Case file: ACP- 323932-25

Re: Part 10 Planning – Response to observations from notified bodies

Part X for the Development of 94 no. dwelling units at (Cornamaddy, Athlone) lands 150m north of the N55, Lissywollen Td., Athlone, co. Westmeath

Response to submissions received from An Taisce.

Proposed Site Layout - Overall Layout
1 : 1000

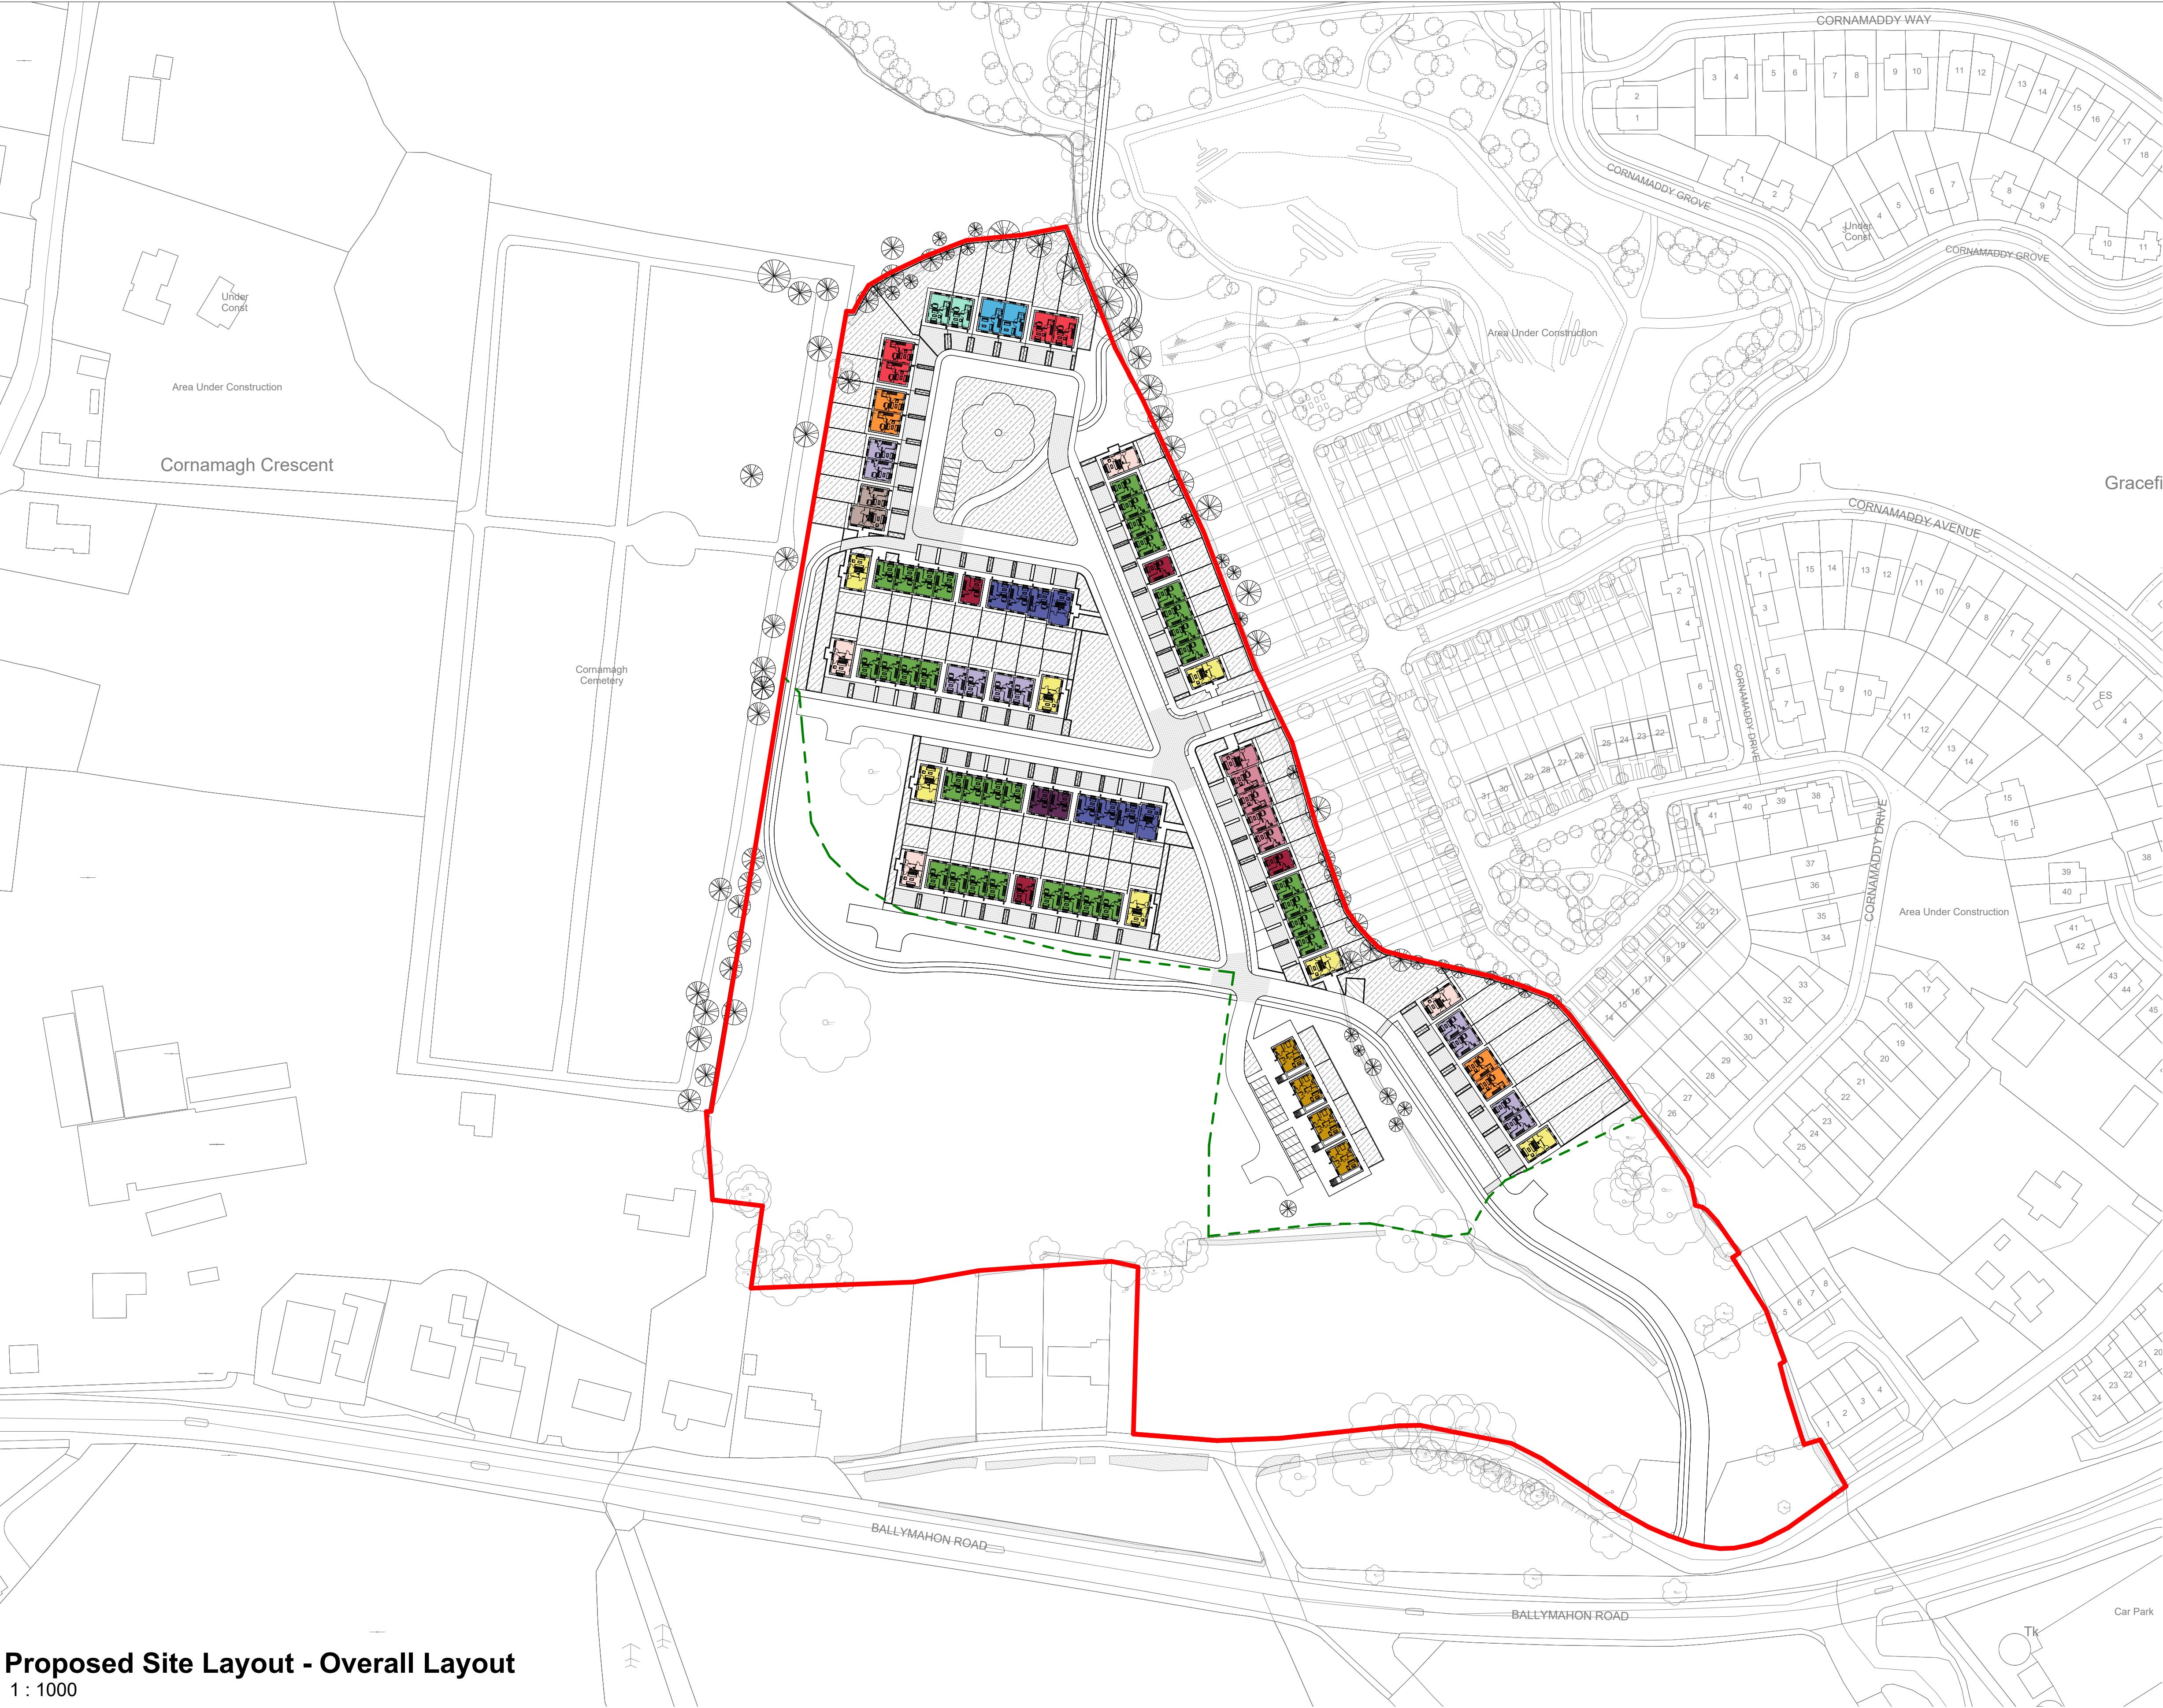
Despite the now widely recognised need to reduce car dependence as part of our efforts to address the climate and biodiversity crises, there is an ongoing systemic failure to ensure that new housing developments are actually linked to safe cycling and walking routes to schools, local services, employment centres, recreation areas, and enhanced public transport in the satellite commuter housing areas. This renders these areas unsafe for walking and cycling to schools, local services and amenities.

Therefore, although a new residential development may provide high quality foot and cycle permeability around the dwellings, these often terminate immediately outside the site boundary, thereby discouraging from using active travel modes outside of the development itself and thereby increasing car dependence.

It should be ensured that the subject proposal's design adheres to the need to promote a modal shift towards increased pedestrian, public transport and cycle friendly development, in adherence to the

With regard to permeability, the Council should have regard to the NTA's guidance which emphasises how permeability contributes to the attractiveness of a neighbourhood. The proposal should also demonstrate adherence to CPO 16.25 within the Westmeath County Development Plan 2021/2027 which specifies the following:

It should also be ensured that the principle of transit-oriented development is embedded into the design of the proposal to tackle car dependency and facilitate sustainable mobility.

The proposed development offers a strong walking and cycling permeability within the boundary of the site, where the generous footpaths are combined with raised 'table top' junctions to provide traffic calming measures and safe pedestrian zones that allow the footpaths and cycle paths to connect to the north south active travel route and provide various routes for cycling and walking within the site boundary.

The design team consulted the Westmeath County Council 'Active Travel' team when considering the cycle and pedestrian access routes. The proposed development will connect to and extend the Westmeath County Council active travel 'route D'. Please refer to the design report and site plan which clearly sets out the proposed extension of active travel routes through the site, these routes reinforce the proposed development sites safe cycling and walking routes to local facilities such as, the greenway, public transport, schools, local services, employment centres, recreation areas.
